Date: 3 July 2024

Application by Total Energies and Corio Generation for an Order Granting Development Consent for the Outer Dowsing Offshore Wind Project

Request for further information

Drawing Title: LOCATION 001 - MARSH LANE / SOUTH INGS LANE / SLOOTHBY HIGH LANE - INDICATIVE PASSING PLACES

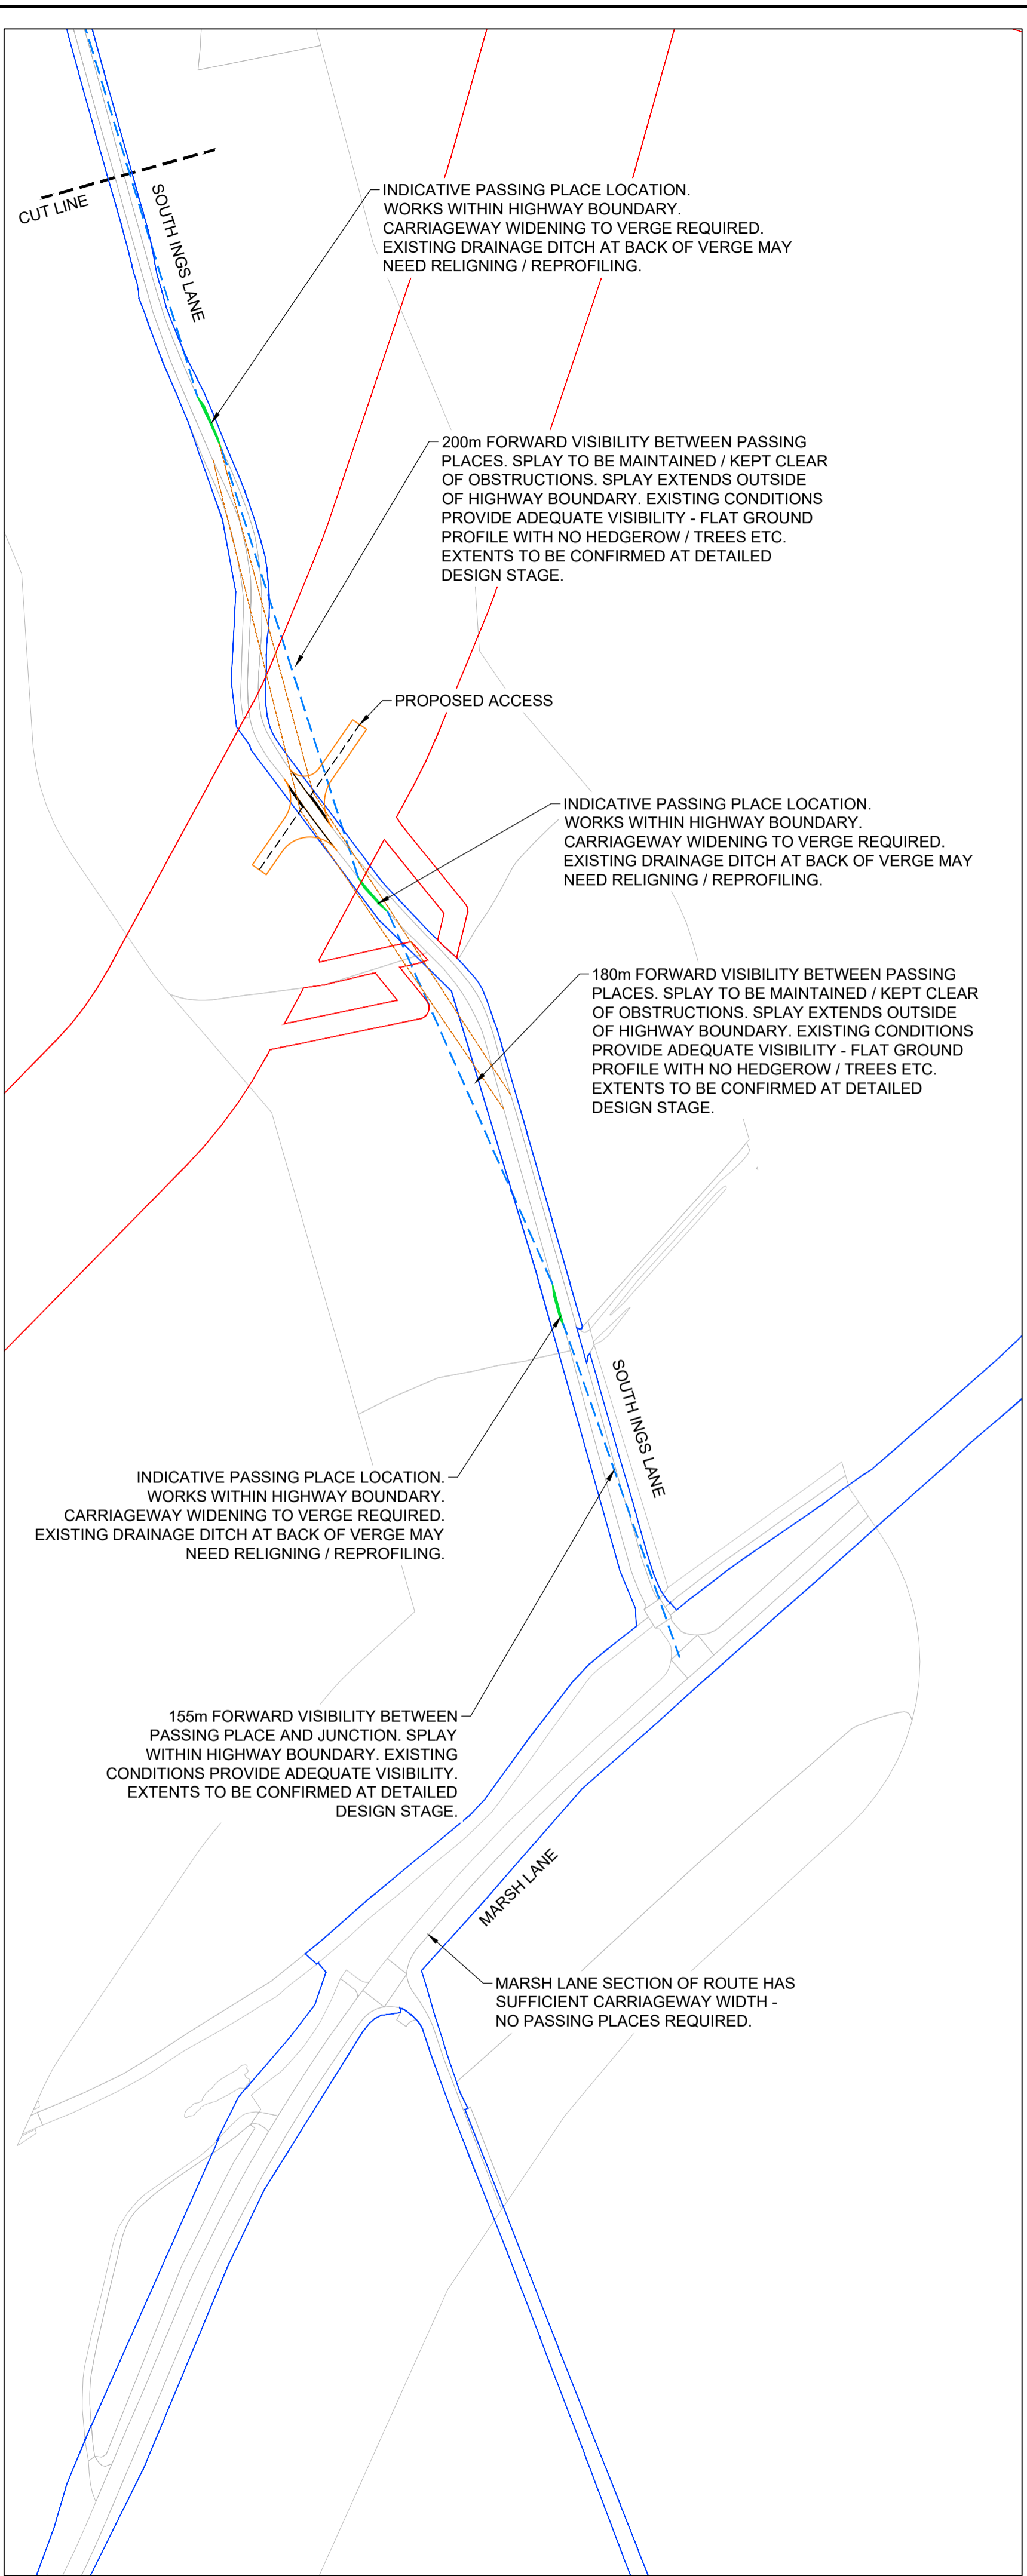
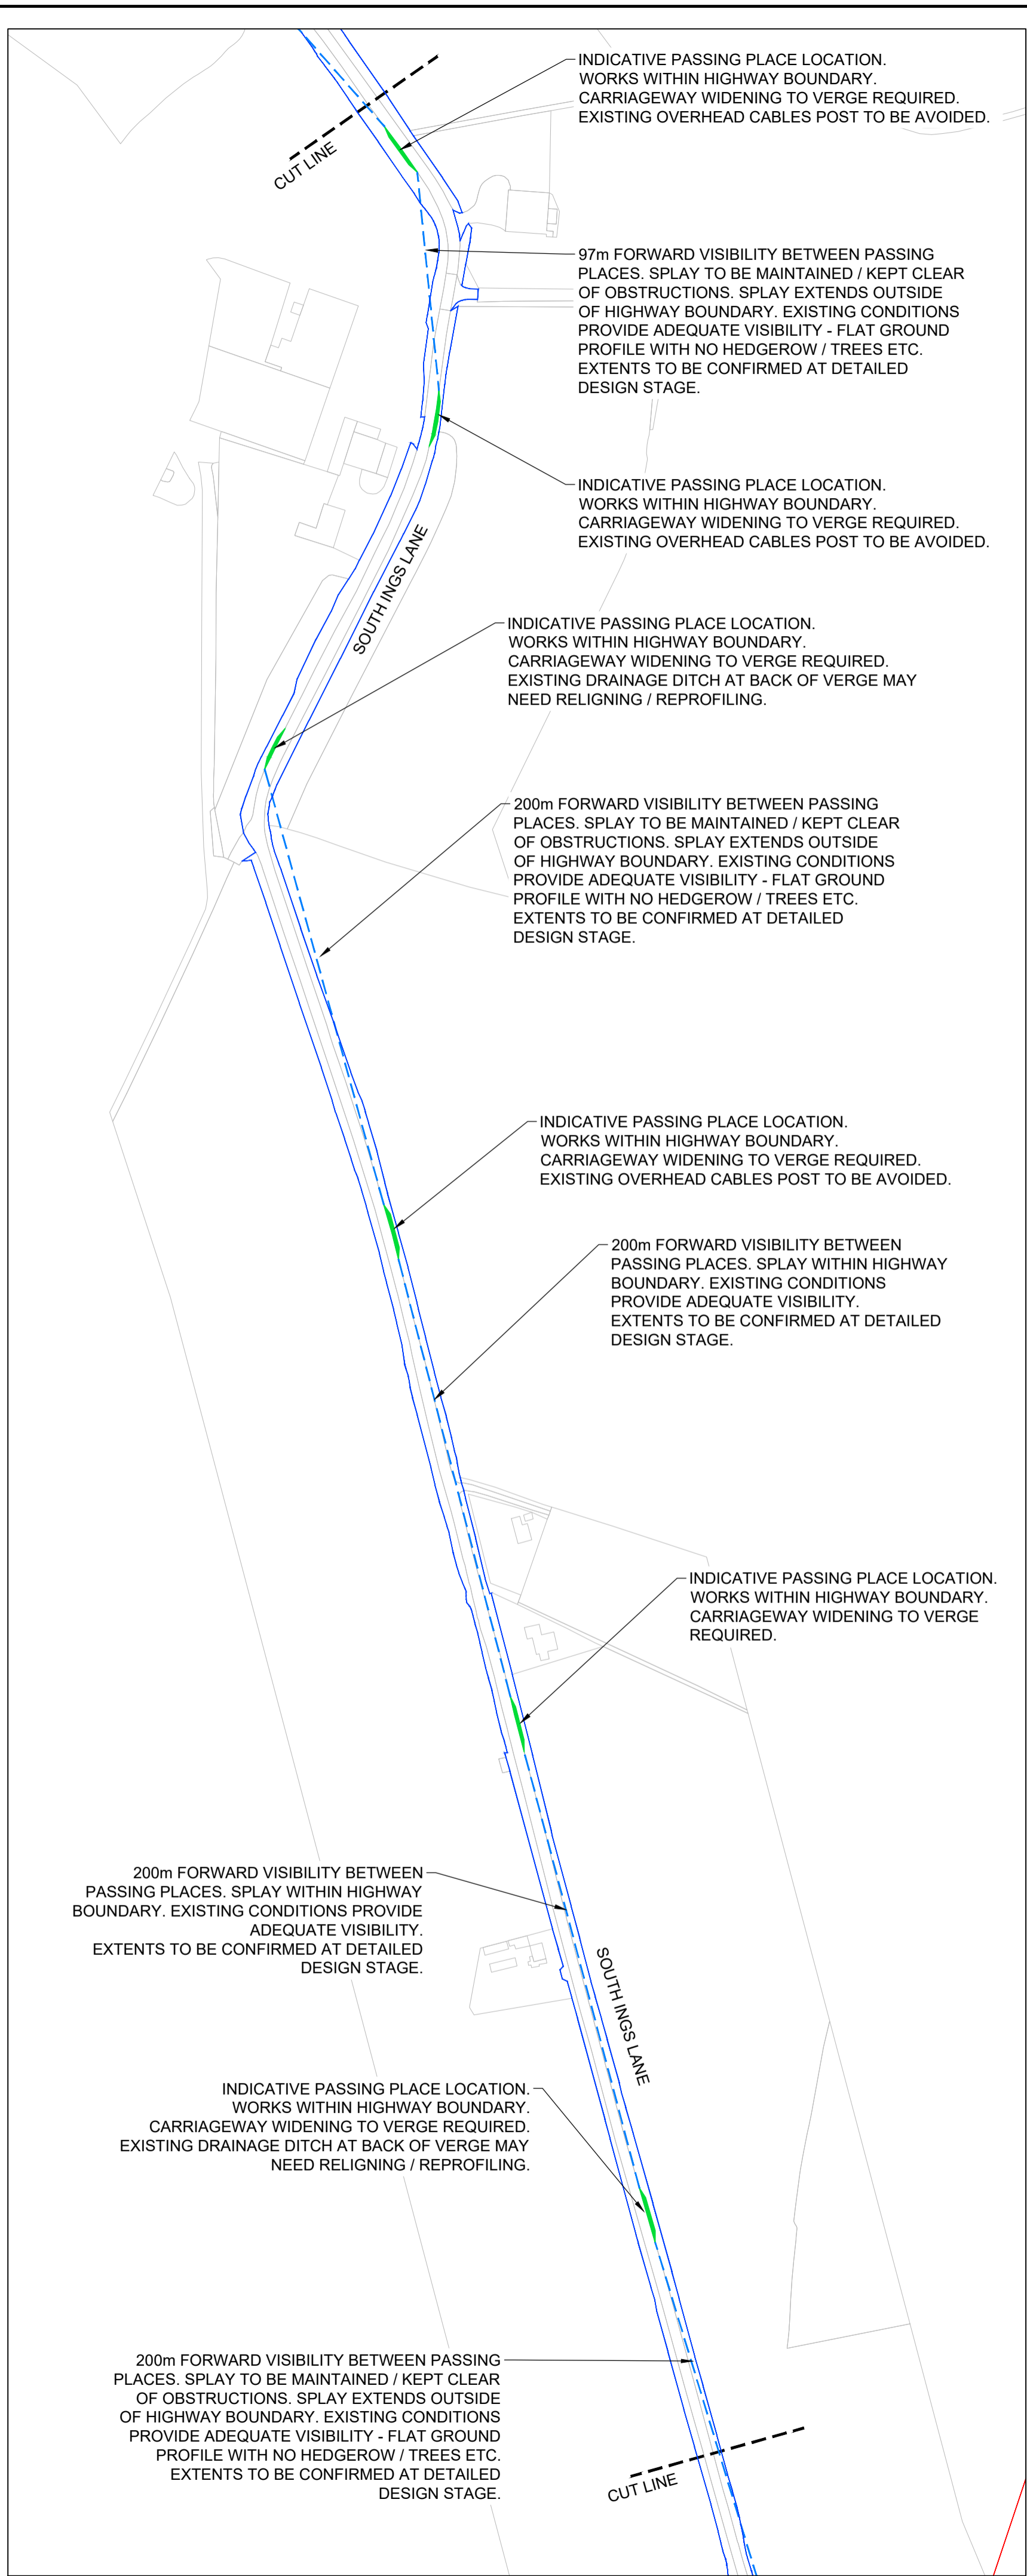
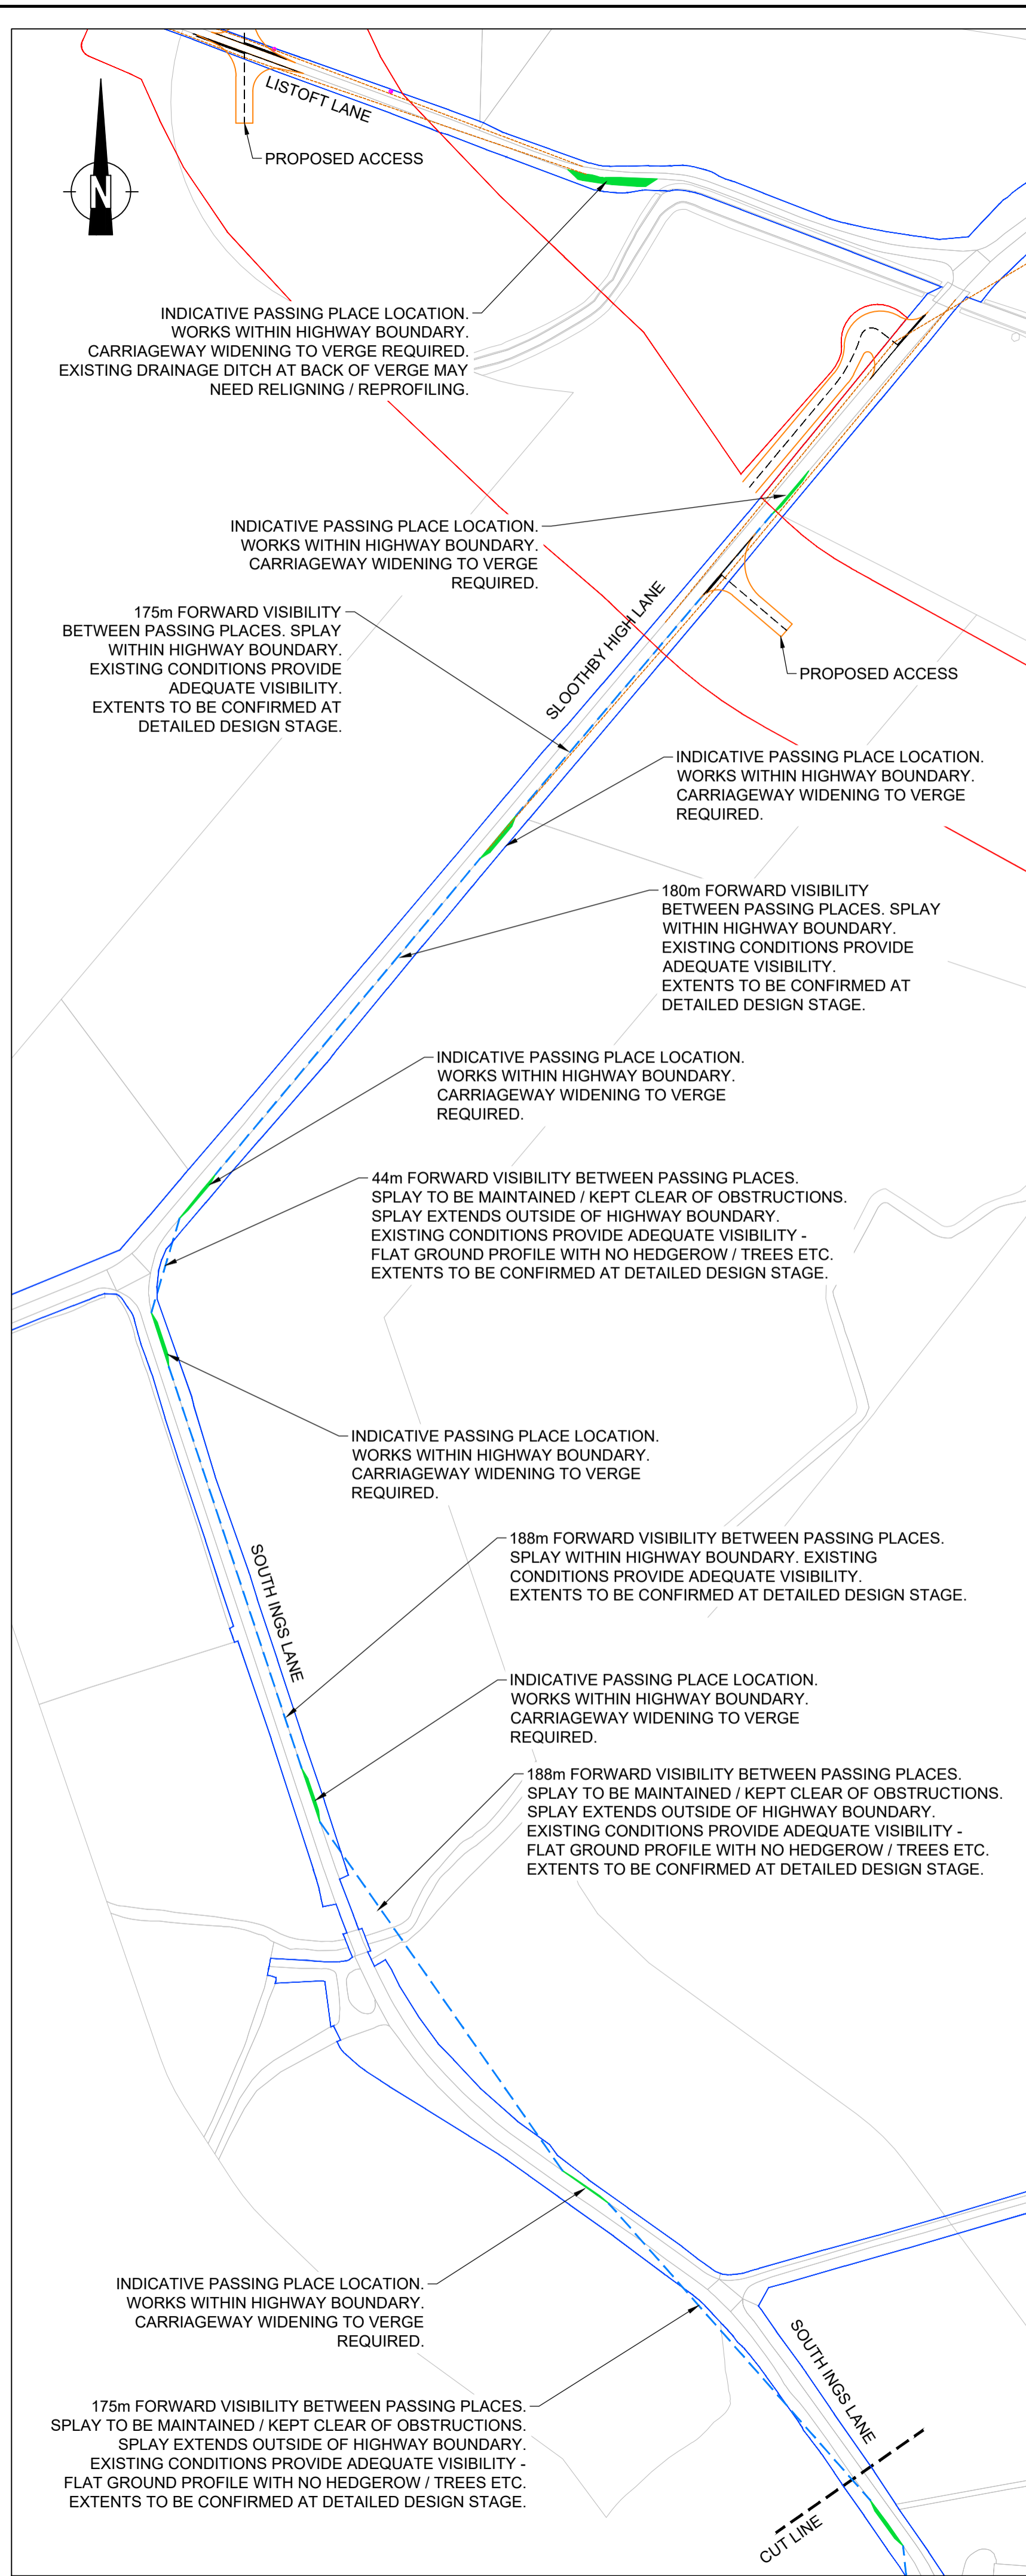
ES Chapter 27 Appendix 1 Transport Assessment Annex N Passing Place Proposal [APP-229] - As shown on page 2, the detailed drawing titled 'Location Reference 002 Boston' appears to be missing. The Applicant is requested to correct the drawing title on page 12 and check the consistency of Location Reference 015 as shown on page 2 with the drawings on pages 13 and 14.
